Sent: ✓ 23 January 2013 09:35
To: Planning
Subject: Welwyn Hatfield Council Online Planning - Comment

NYN PARK

Application Number: S6/2012/2608/MA
Name: Dr and Mrs H Reid
Address: 48 Vineyards road, Northaw
EN6 4PA

TITLE
Proposed Boundary Fence (60f6)

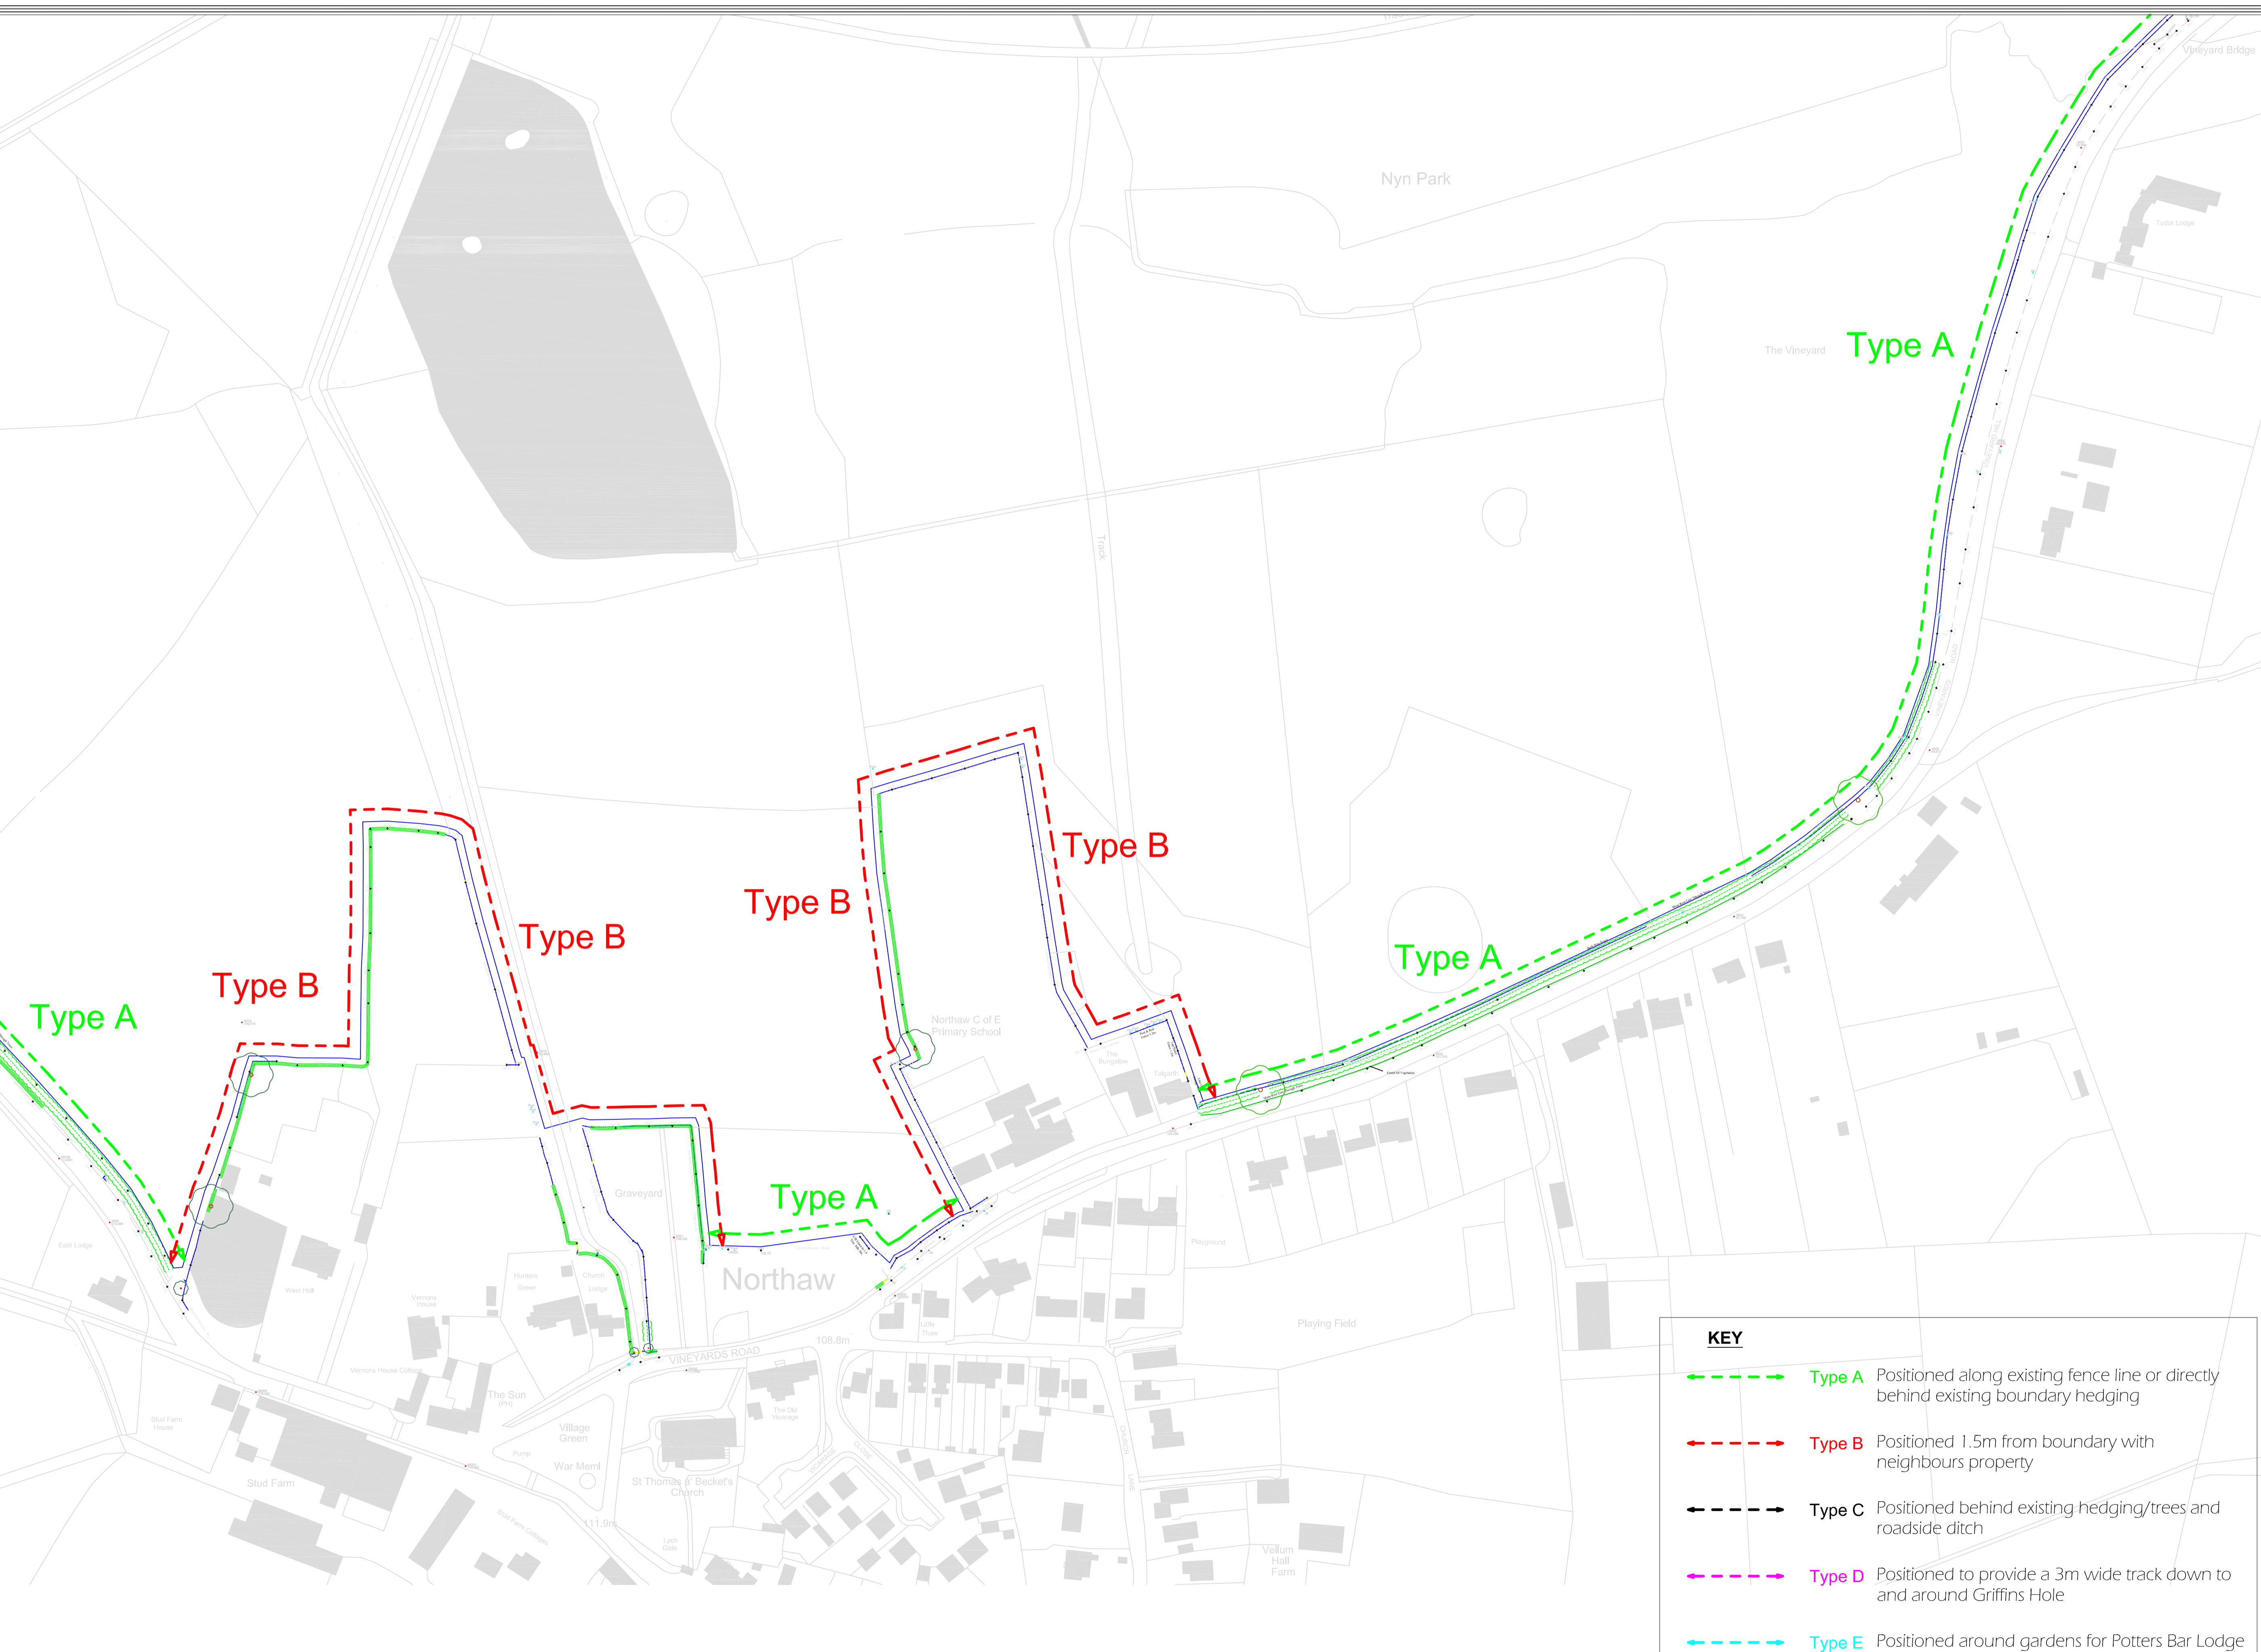
Comment: Having viewed the plans as they were available at the time, at the Planning Office, we would like to comment on the fact that the projected fence is to be black, green would be less obvious as it is going to make quite an impact down this road. It is difficult to consider the mess of growth, on the roadside, as a hedge. Vehicles catch it all the time as the growth is rampant. We trust this will be considered at the same time as the fence.
